Objection to Amended State Significant Development Application

SSD-61400212

Crows Nest Over Station Development - Site B

25 Hume Street, Crows Nest

Sheet title  
CARPARK LEVEL 05

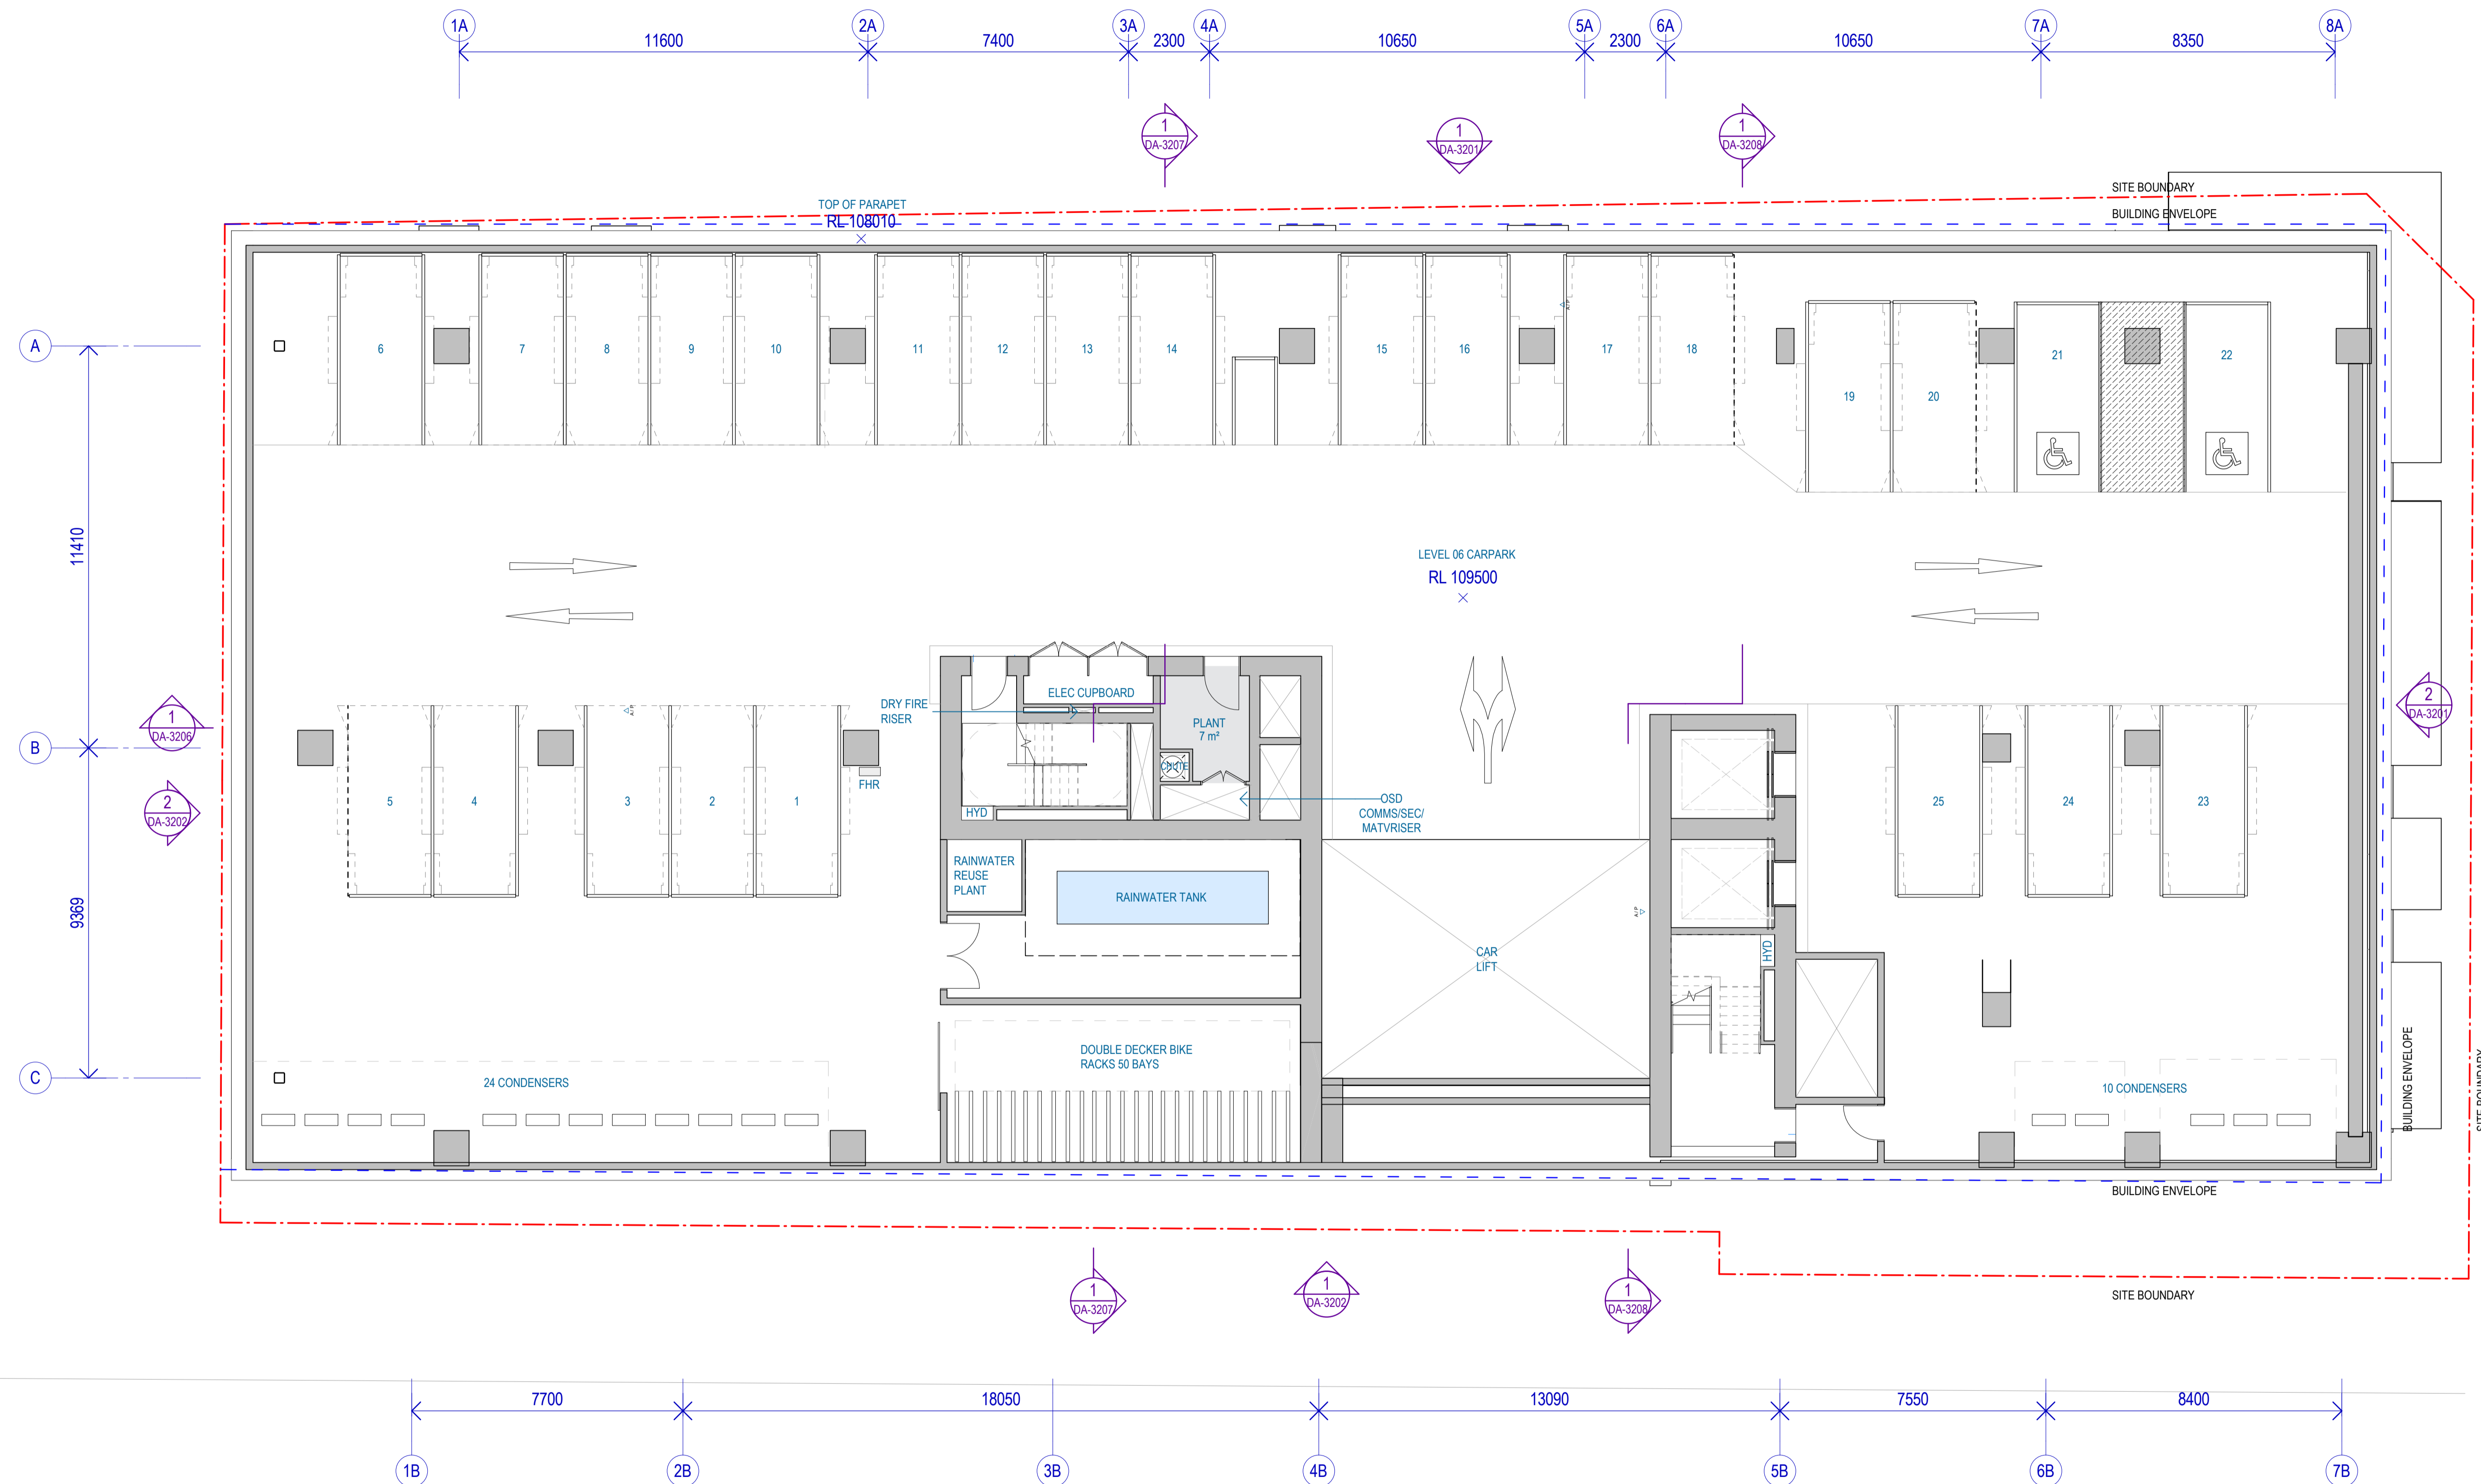
- **Increased Car Parking at the Expense of Housing:** The most egregious amendment is the decision to replace an entire residential floor (Level 7) with an additional level of car parking. This specific action increases the car parking provision by 42% (from 55 to 78 spaces) at the direct expense of eight residential apartments, reducing the total yield from 130 to 122 units.

- **Operational Risk of Mechanical Car Lifts:** The reliance on two mechanical car lifts to service 78 parking spaces presents a significant operational risk. While the proponent's queuing analysis predicts minimal impact (of course), this model does not adequately account for peak usage conflicts or the potential for mechanical failure. A breakdown of one or both lifts could lead to significant vehicle queuing and traffic chaos on Clarke Lane, a narrow and vital local accessway.
